DECISION DELEGATED TO HEAD OF PLANNING

Application No: H02-0837-25 **Applicant:** Mr & Mrs I Smedley
Proposal: External & Internal Alterations
Location: The Manor House 5 East Street Crowland
Terminal Date: 23rd January 2026

This Listed Building Consent application is for external and internal alterations to The Manor House, 5 East Street, Crowland.

Drawing Title
Existing paneling ground floor
The Great Room G10

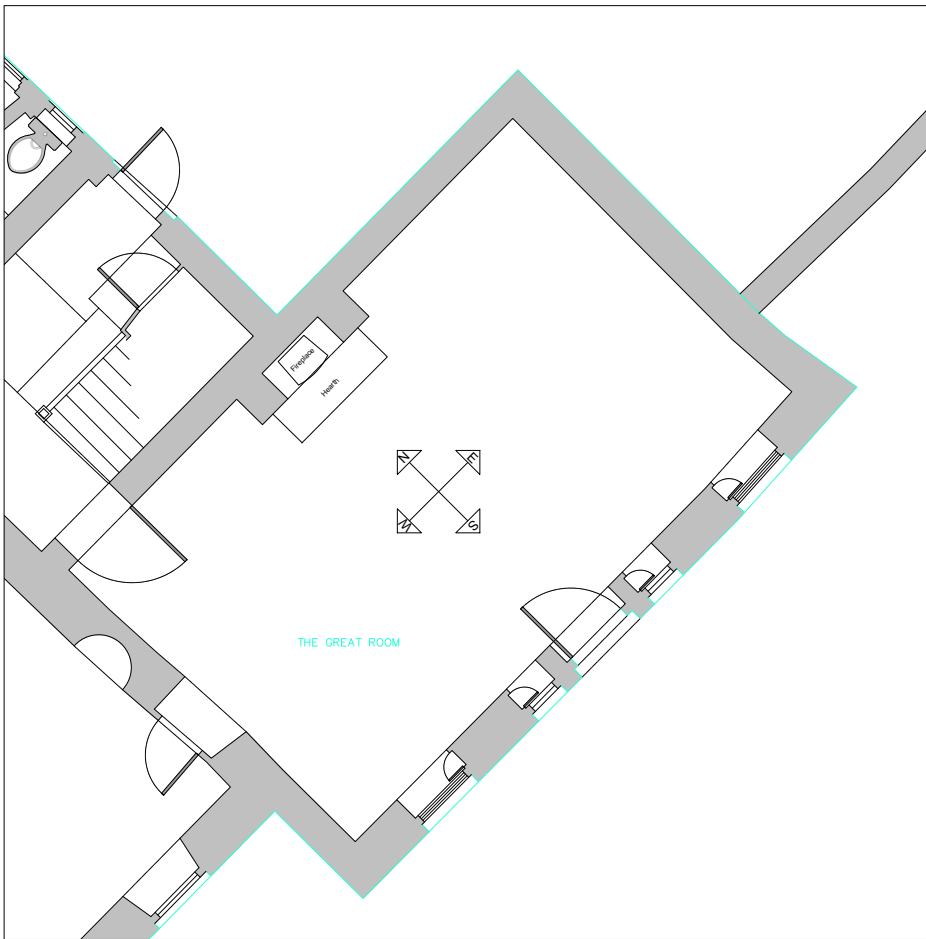
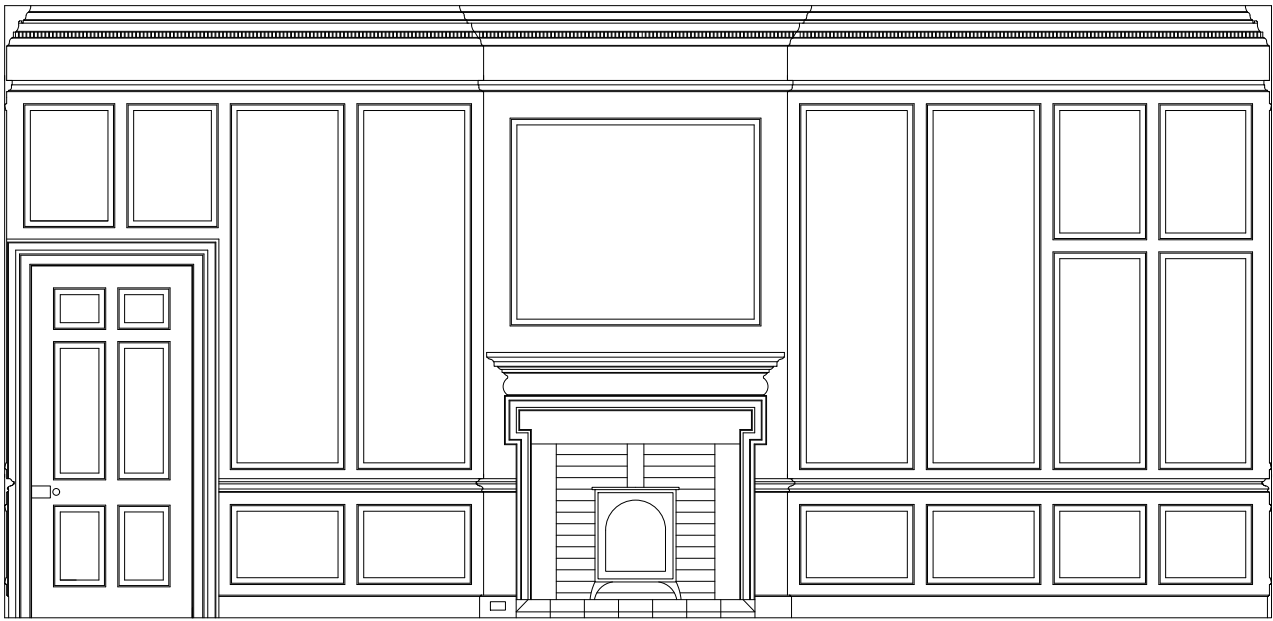
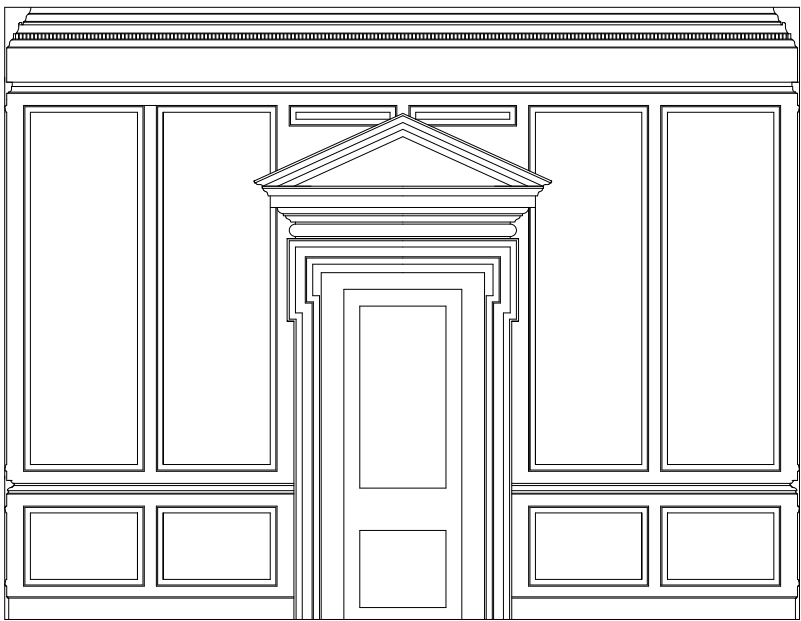
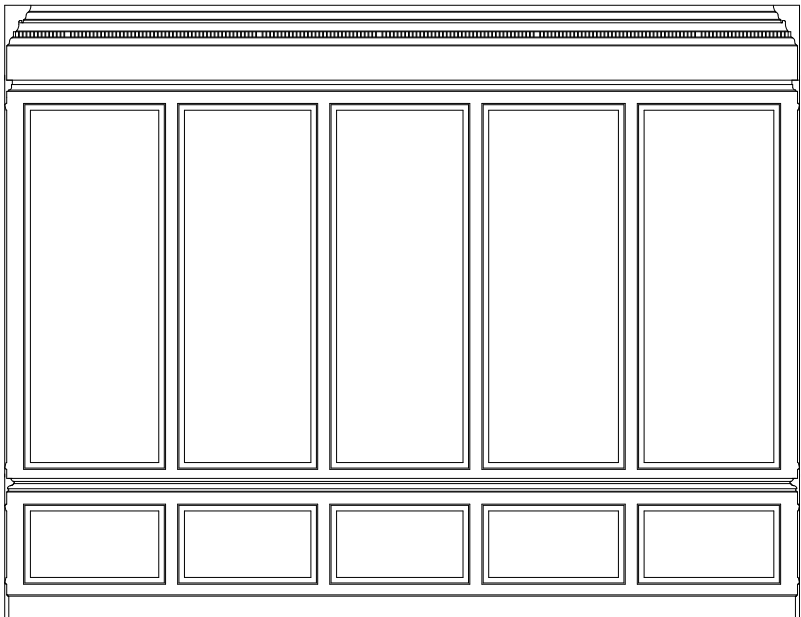
On the inside there are additional proposed works, including the removal, storage and reinstatement of timber panelling and floorboard in the rooms marked as G6, G10 and F9 on plans 438-44.P21A and 438-44.P22 respectively. This work is requested purely for investigative purposes, and the consent shall be for the reinstatement of the existing back in the same order following structural investigations. Therefore, with the application of suitably worded conditions requiring the proper storage of the panels and boards and reinstatement, there should be no overall impact upon the site whatsoever.

Bedroom F9,
scale 1:100

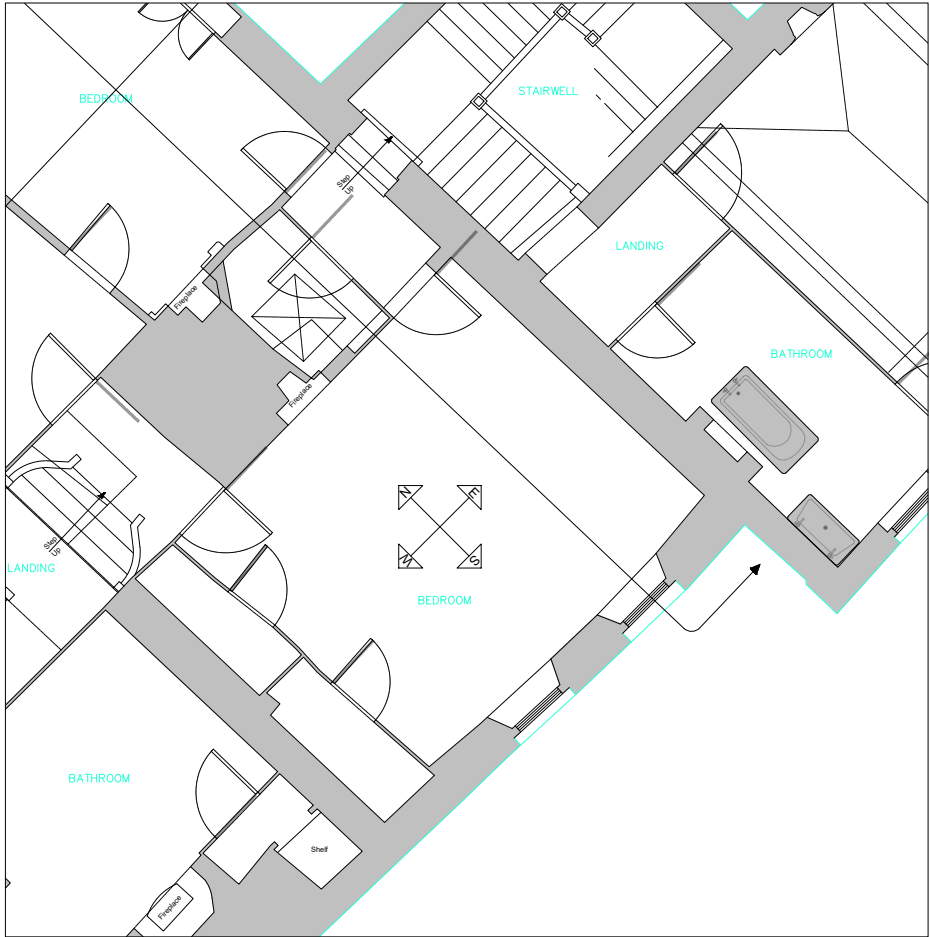
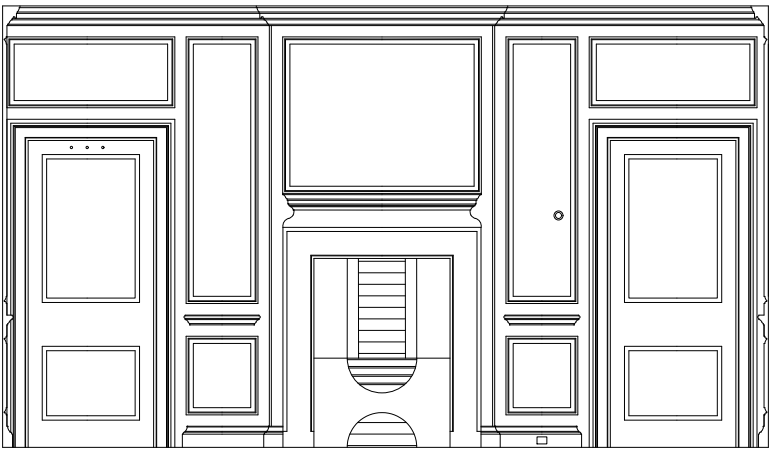
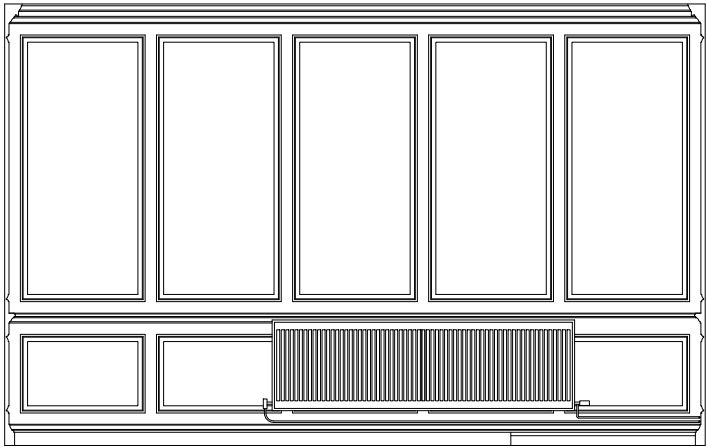
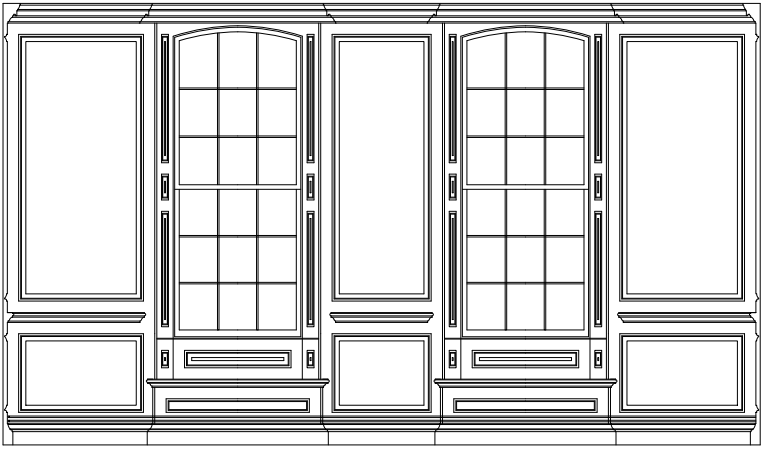
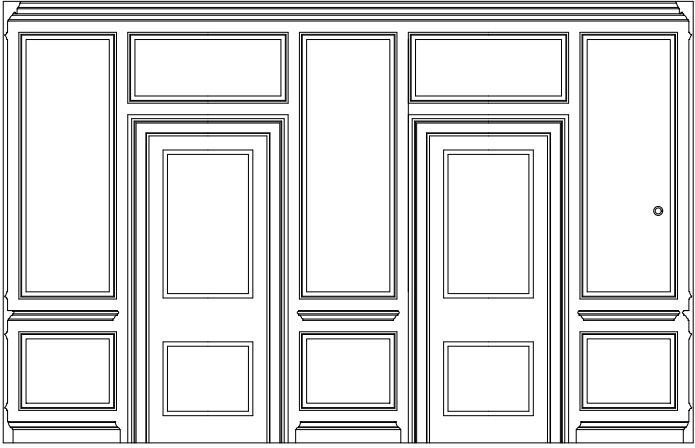
The proposed opening-up work appears to impact a large extent of historic fabric in rooms F9, G6 and G9. We note that some of the investigative work has been previously consented, however we still encourage that the extent of opening-up works is kept to the minimum required.

We recommend that further information is provided to justify the extent of panelling proposed to be removed, to assist in balancing harm against benefit and to ensure that any unnecessary harm to

We also previously recommended that further information is provided to justify the extent of panelling proposed to be removed. We have seen additional information regarding this (omitted accidentally from H02-0837-25 amendment application) but provided to us separately. The additional information document (Photographs - Additional Information provided by Hutton + Rostron) consists of photographic evidence of the removal of panelling from the Great Room dating to 2001. We acknowledge that panelling has previously been altered and in light of this we refer to your Conservation Officer for further guidance on this matter going forward."

Existing rear (south) elevation

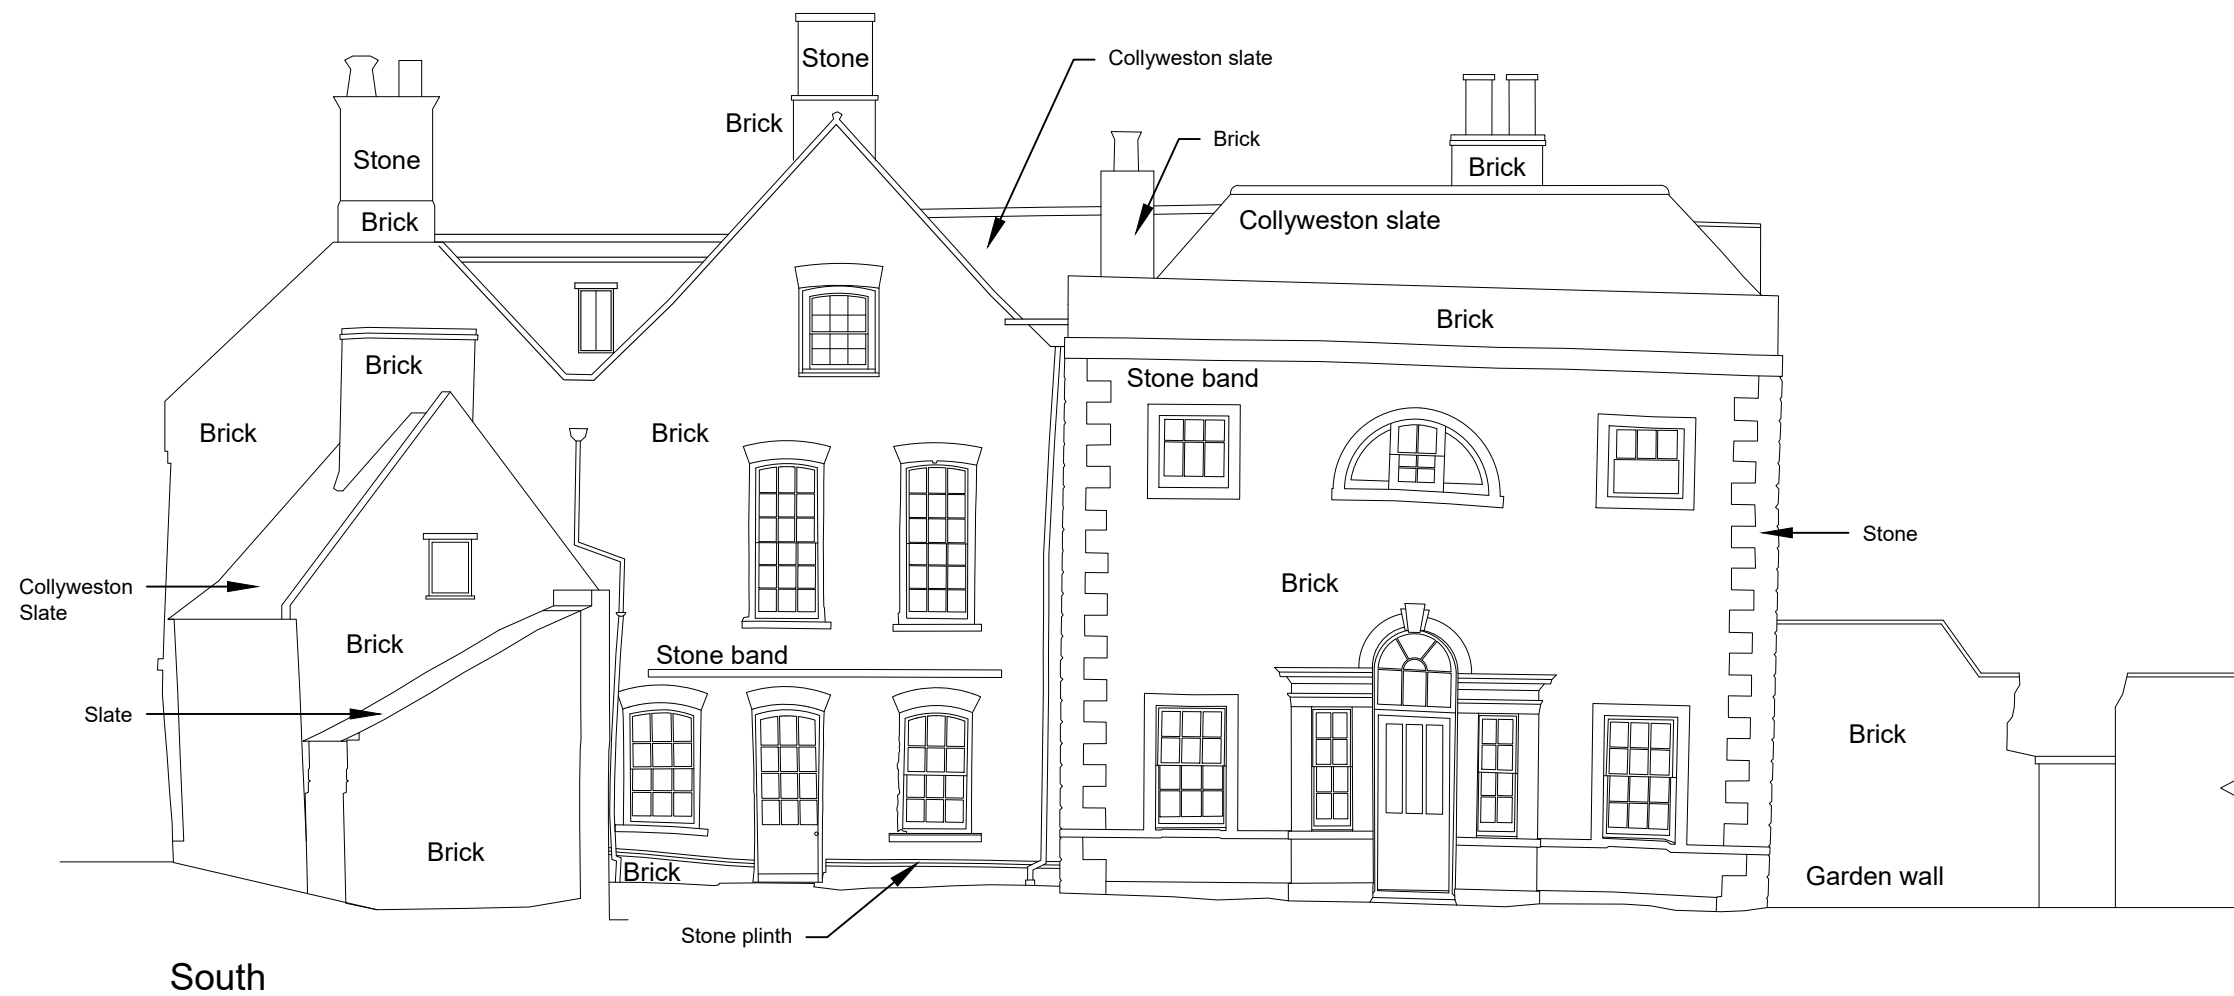
We also recommend that further detail is provided of the chimney stack proposed to be to be reinstated (such as design and materials) to allow a fully informed impact assessment, and evidence of the poor condition of the other chimney stack to justify its removal.

The next most significant alteration to the exterior of the building is the rebuilding and reinstatement of two chimneys. The chimney to be rebuilt is the chimney on the south end of the western frontage wing of the property. The proposal is for the chimney to be rebuilt like for like as it is currently of structural concern. A like for like rebuild is obviously not of any harm to the overall character of the asset. However, given the significance of the roof design and engineering to this listing, the rebuild will require scrutiny over methods and materials. Therefore, in line with the recommendation of Historic England, a suitably worded condition shall be applied ensuring that full details of the rebuild including method statement and item specific drawings shall be applied.

"We thank the applicant for the additional information provided in the Heritage Statement in response to our previous comments regarding the rebuild of the chimney (to south end of phase A). We still consider that a chimney reconstruction plan is necessary (which has not yet been provided) however we are happy for this to be dealt with via condition discharge, along with details of materiality.
